**KIRKLEES METROPOLITAN COUNCIL
DEVELOPMENT & MASTER PLANNING SERVICE**

**DELEGATED DECISION FOR PRIOR APPROVAL FOR CHANGE OF USE
FROM COMMERCIAL, BUSINESS AND SERVICE USES TO
DWELLINGHOUSES**

Reference no. 2023/CL/92103/E

Site Address	Dixon Hall And Co Ltd, Grafton Street, Batley, WF17 6AR
---------------------	--

TITLE: SWEPT PATH ANALYSIS
STANDARD DESIGN VEHICLE (CAR)

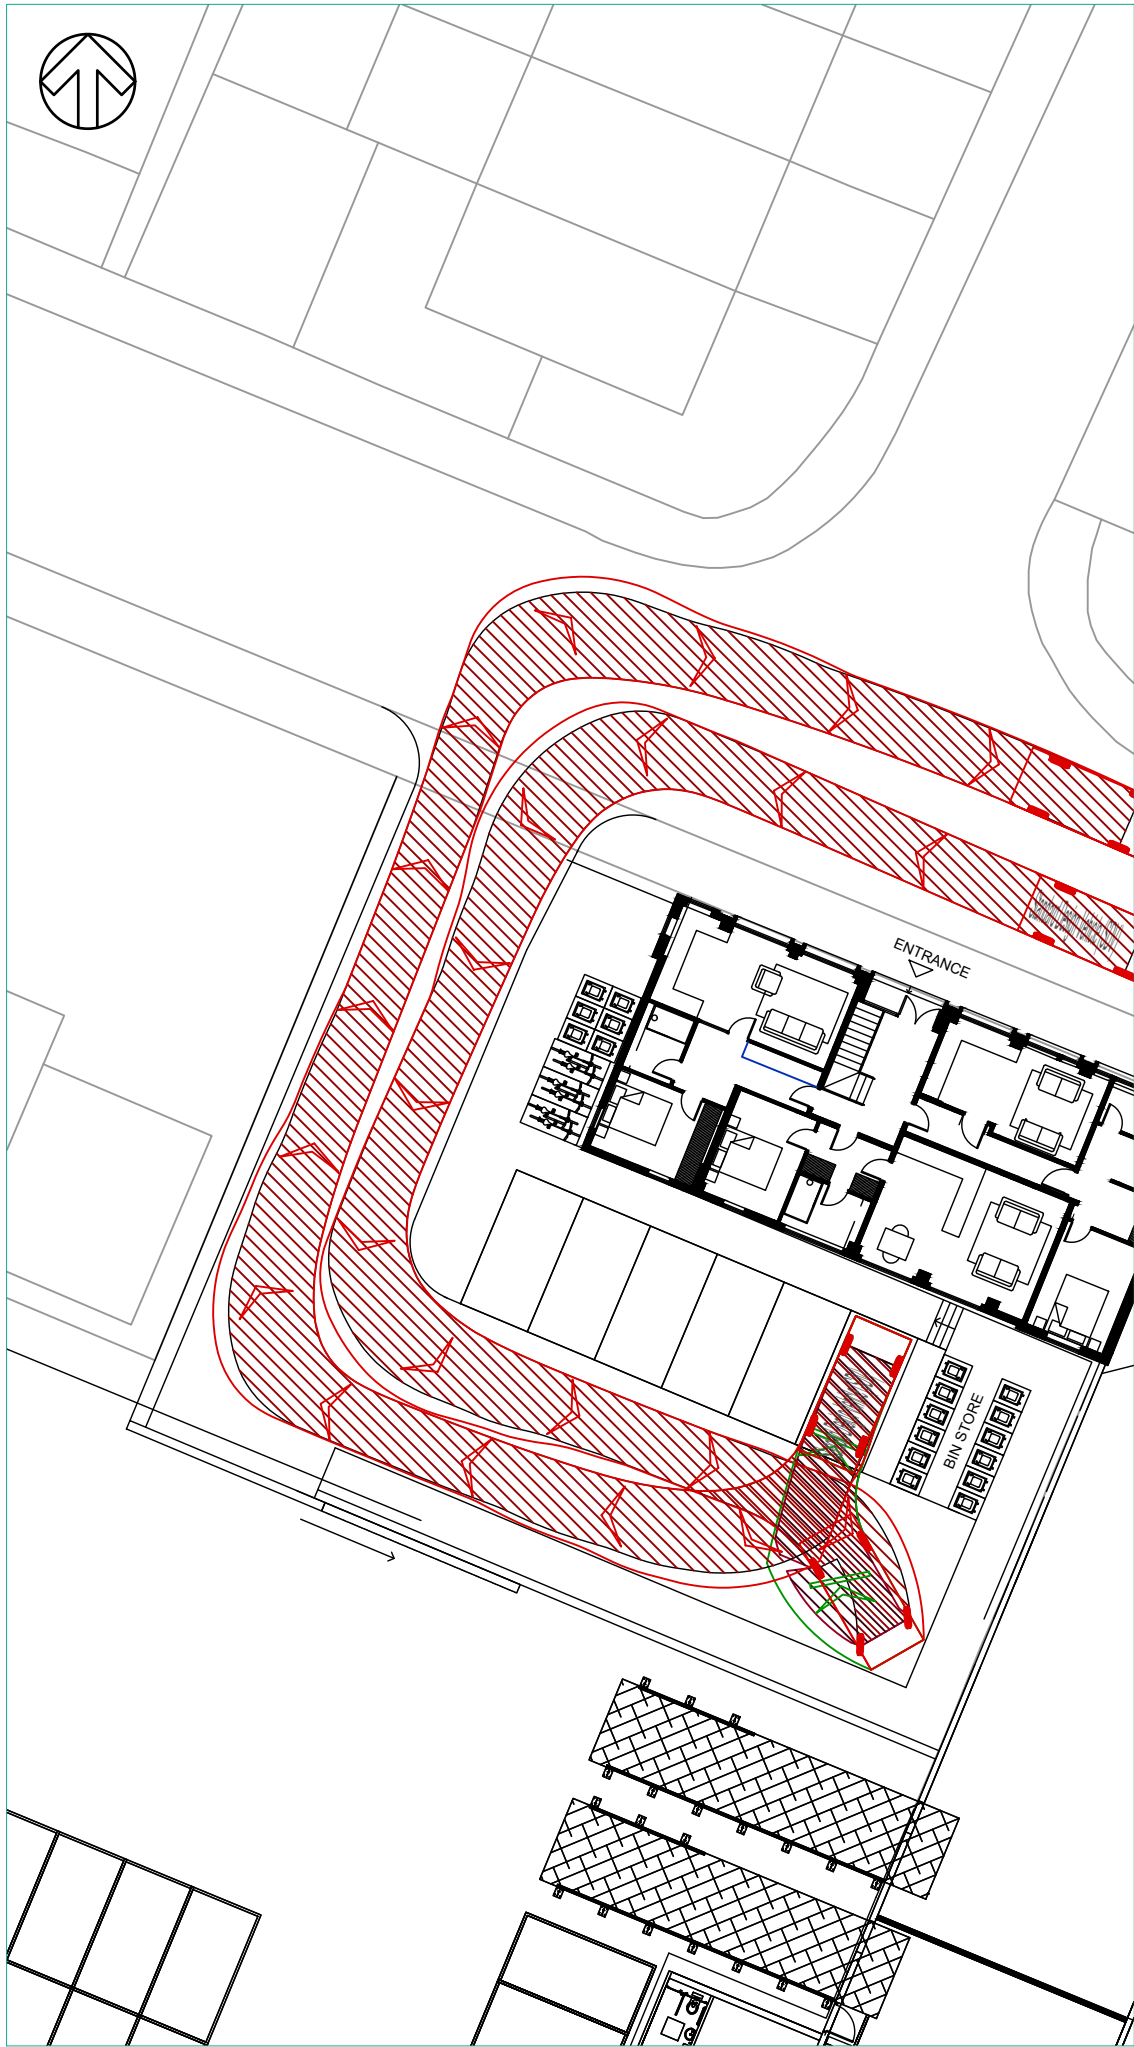
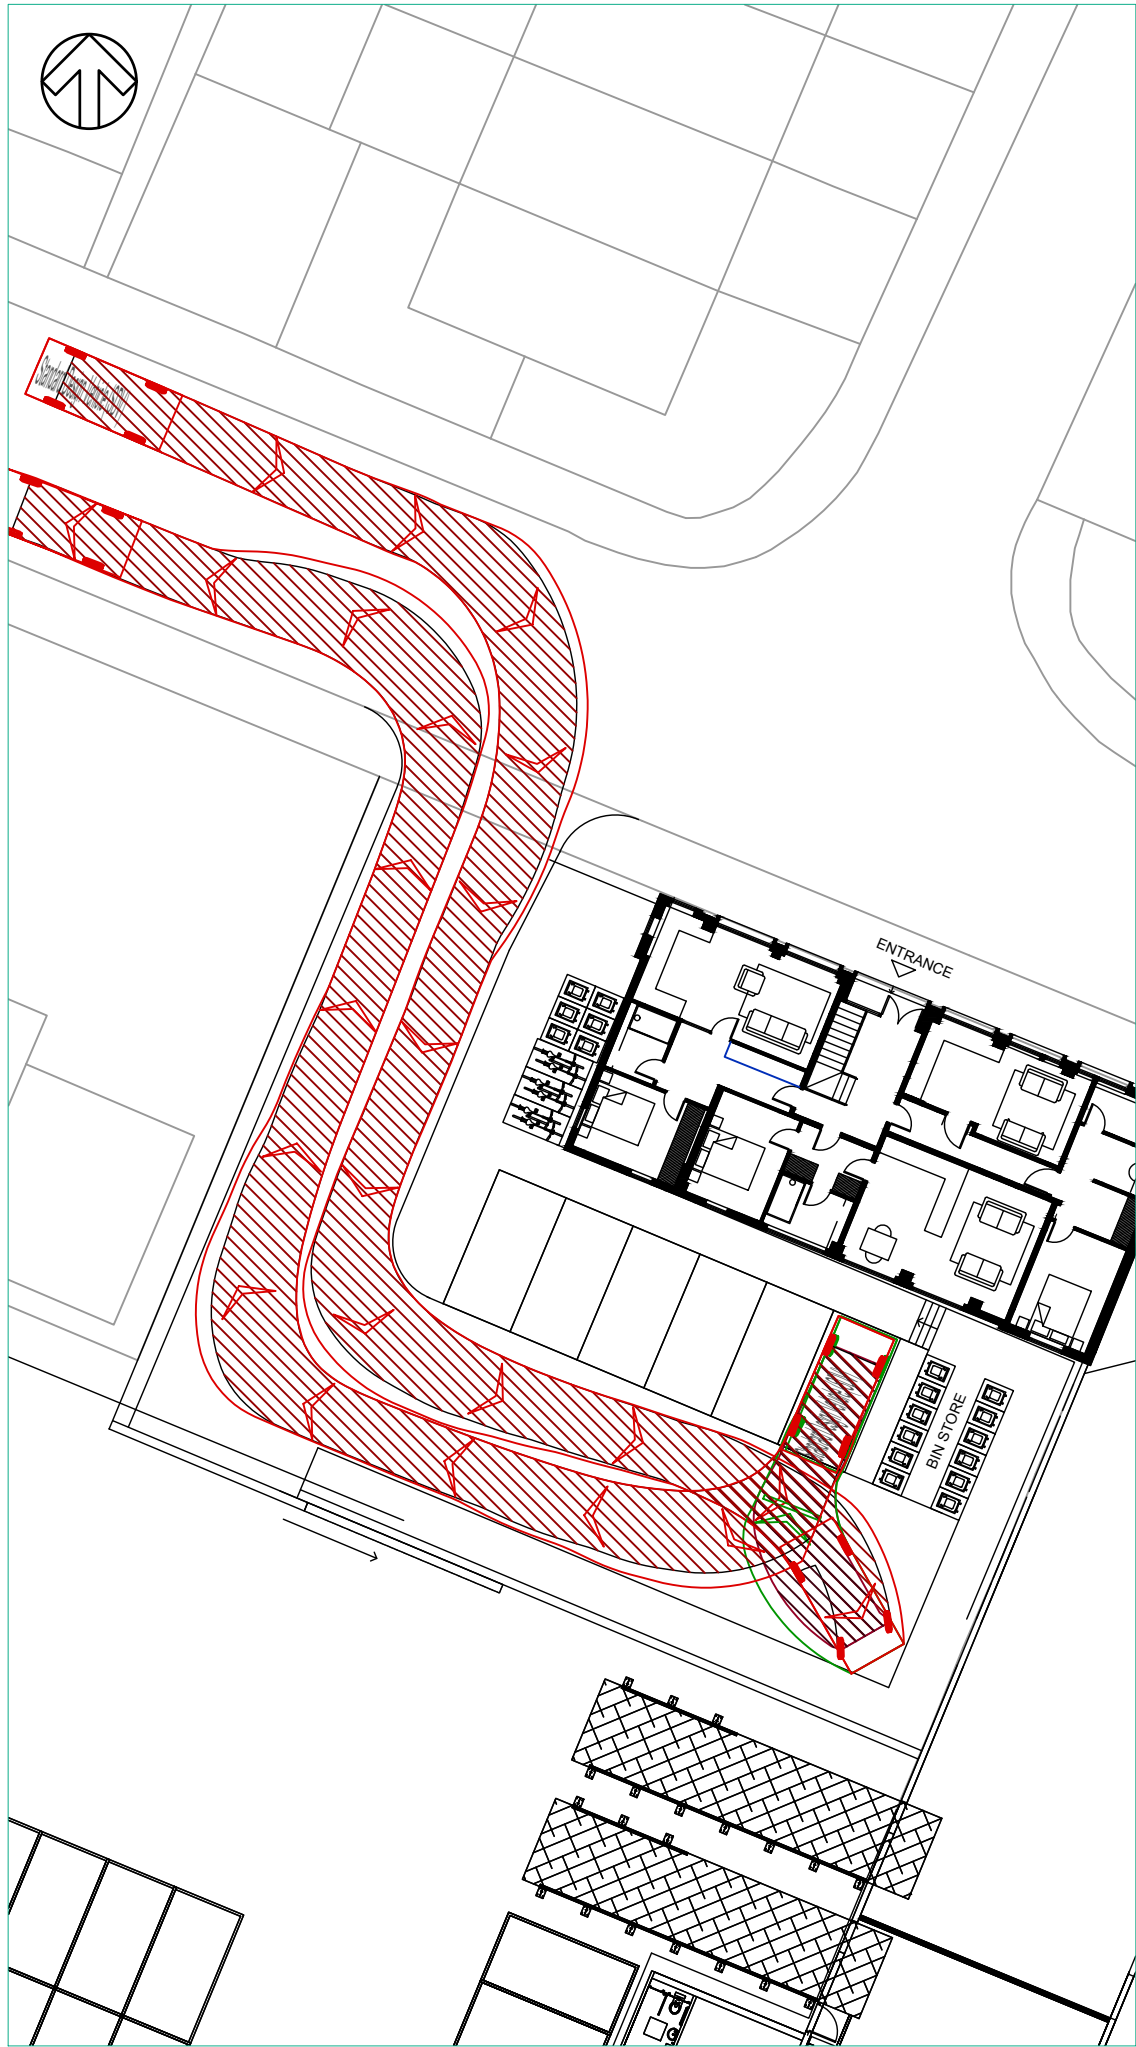
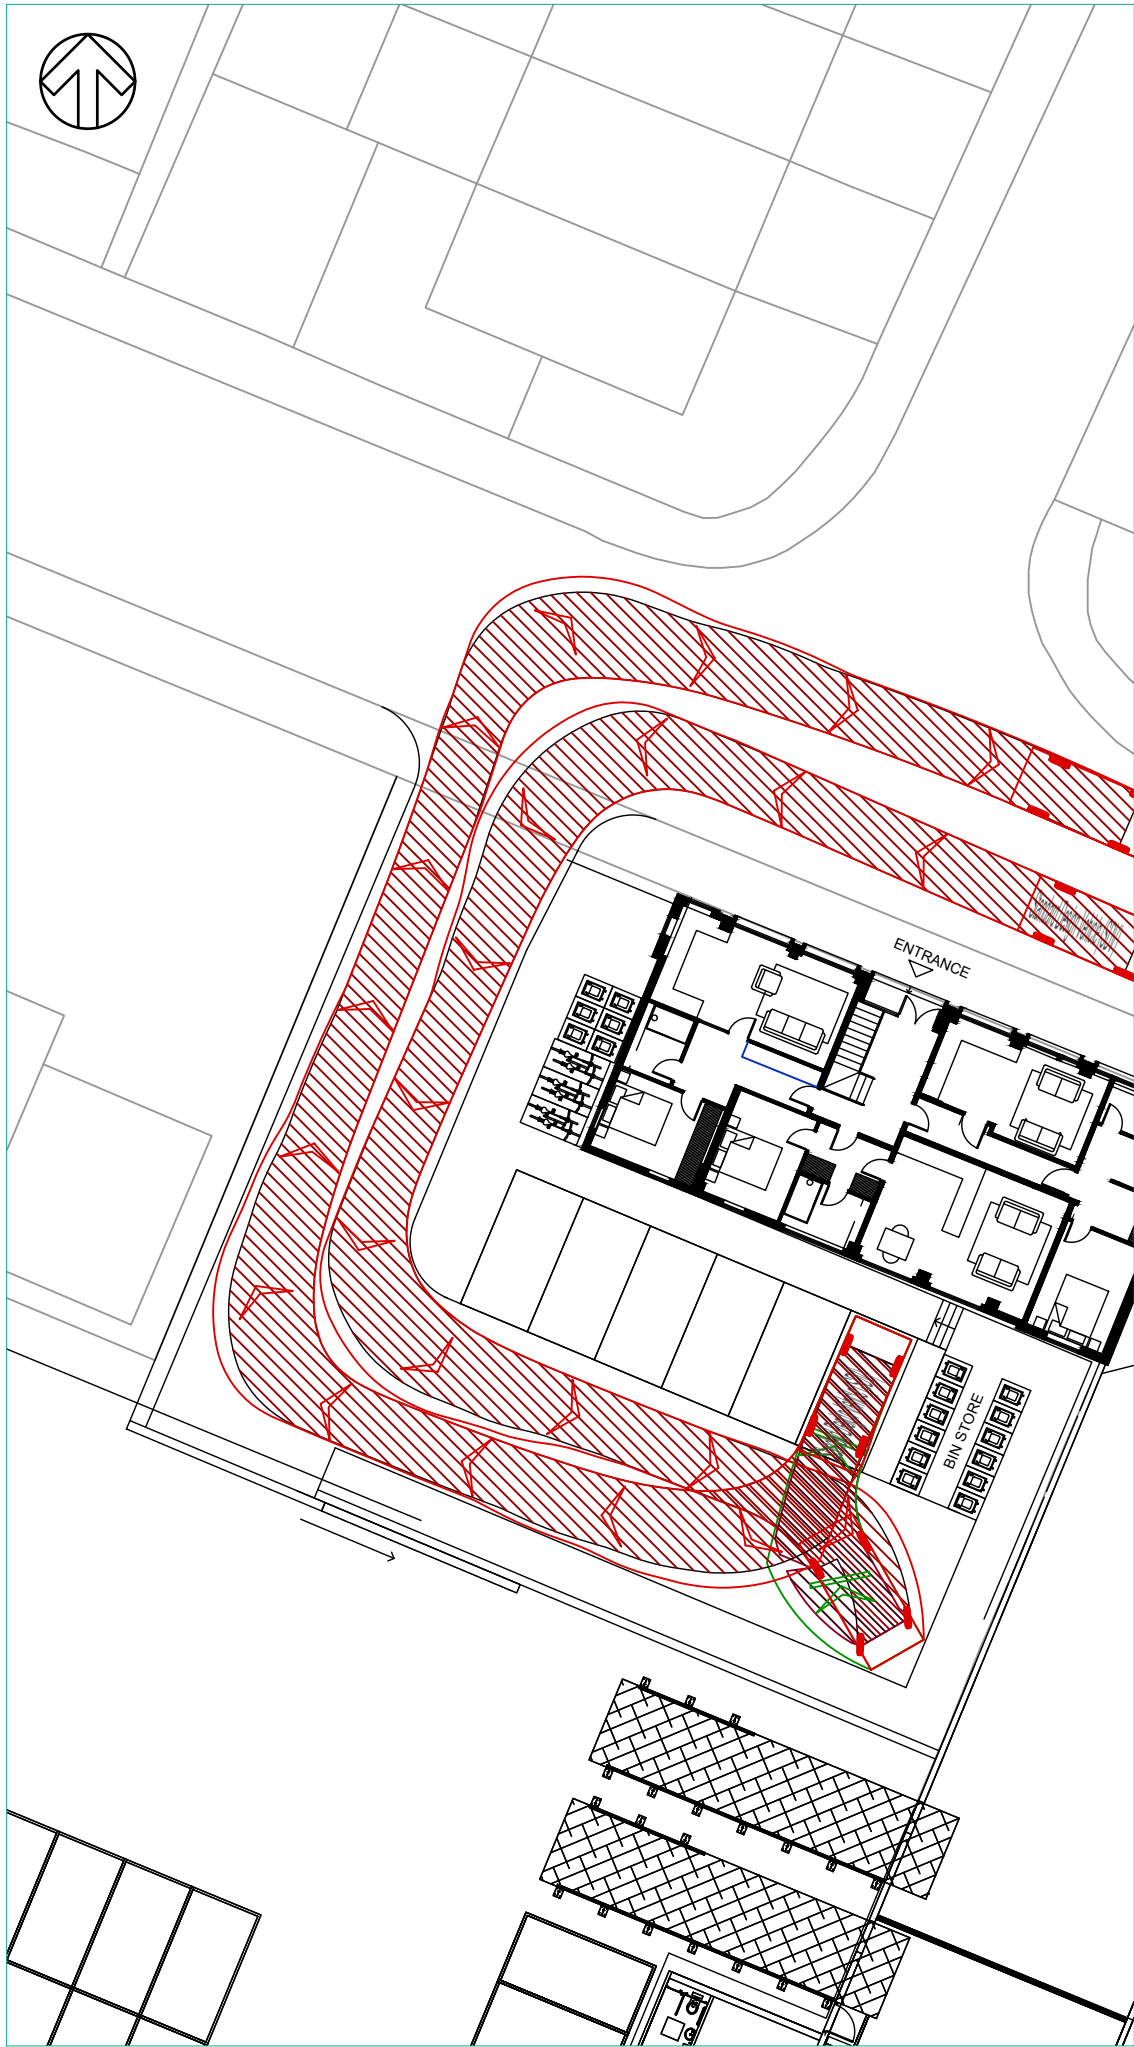
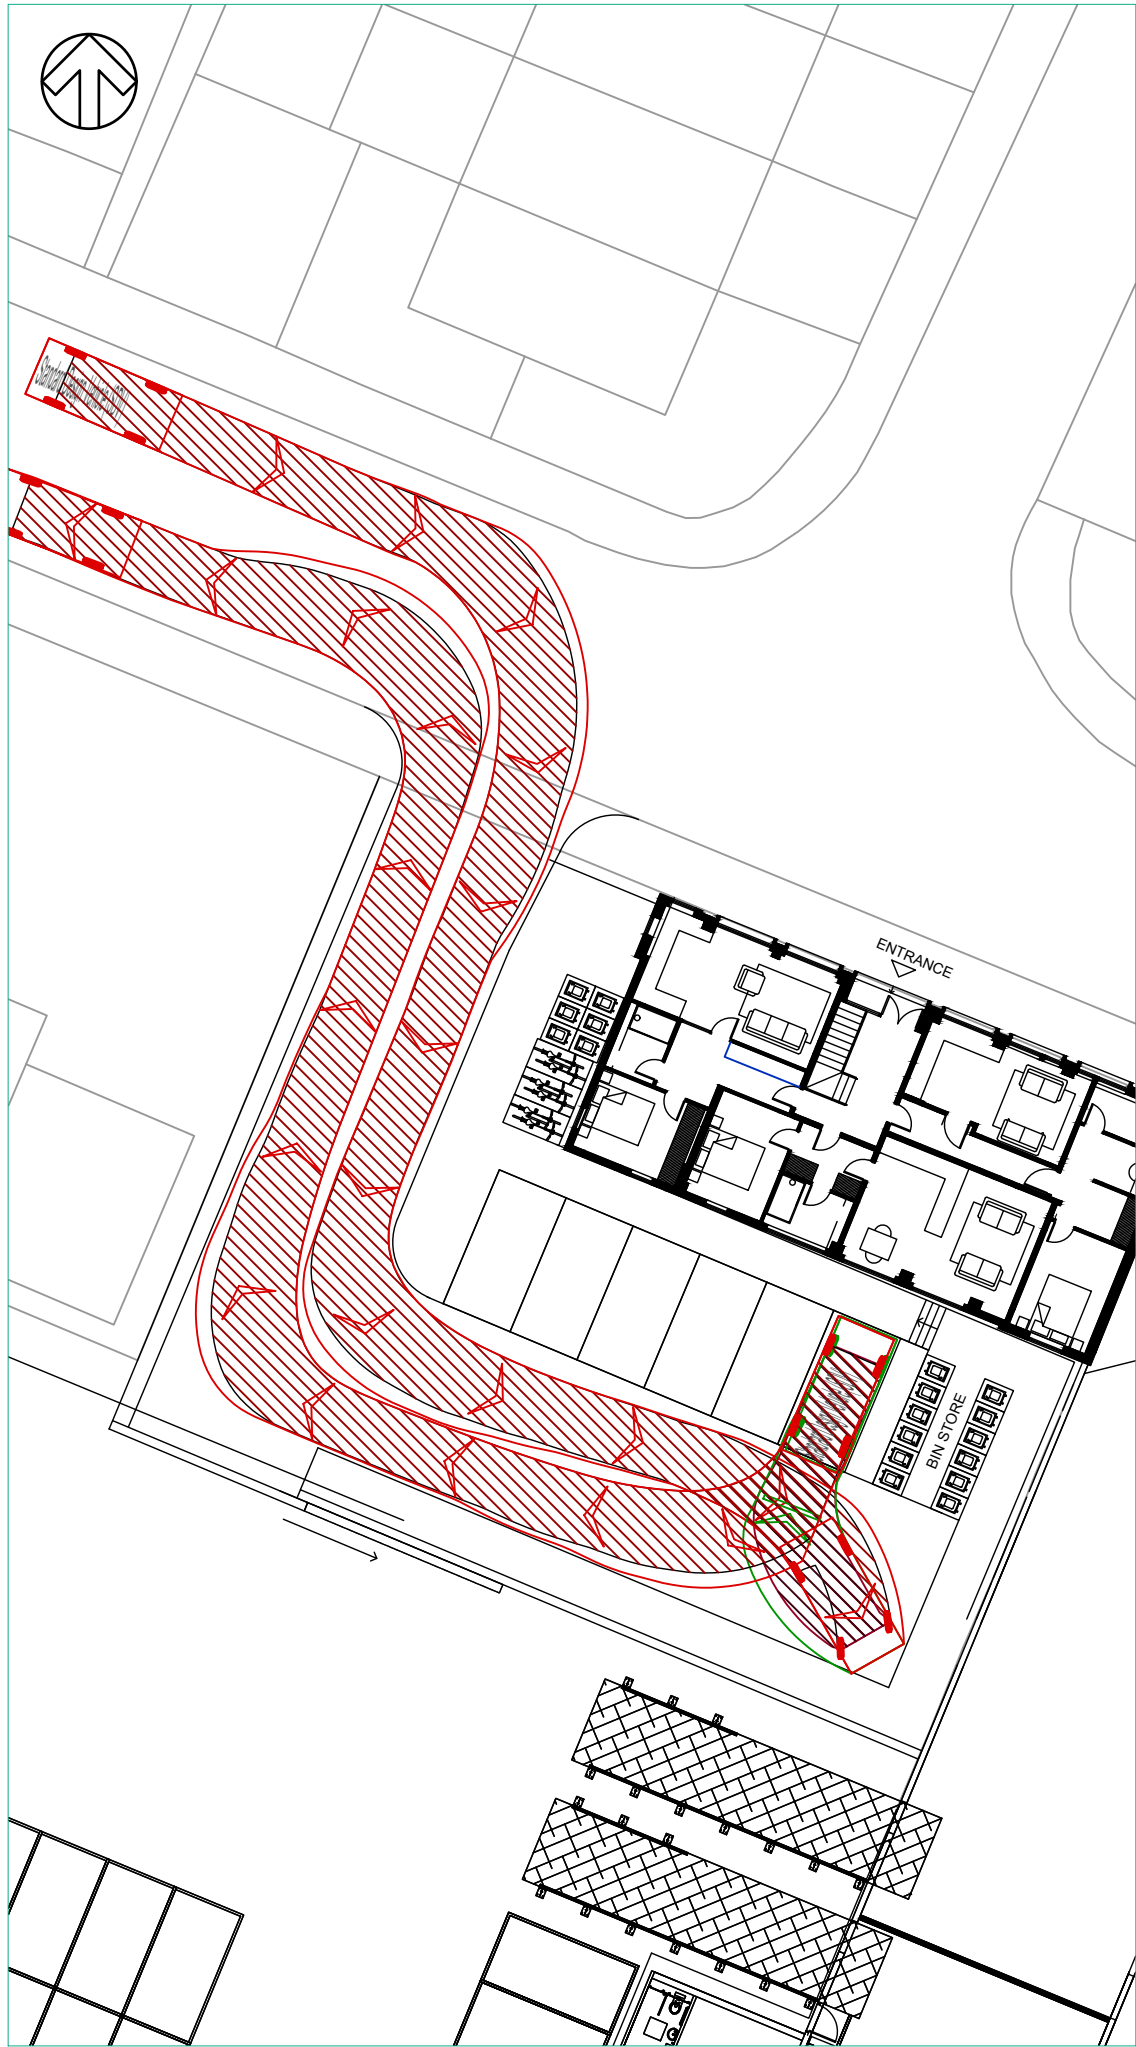
Submitted plans are insufficient for KC Highways Development Management to support the application. Swept paths do not show the largest vehicle likely to enter, exit and turn within the site considering the adjacent 'Dixon Hall Tools' site. There would be obstructed visibility for vehicle exiting the proposed parking area and vehicles exiting the access to the remainder of 'Dixon Hall Tools' site.
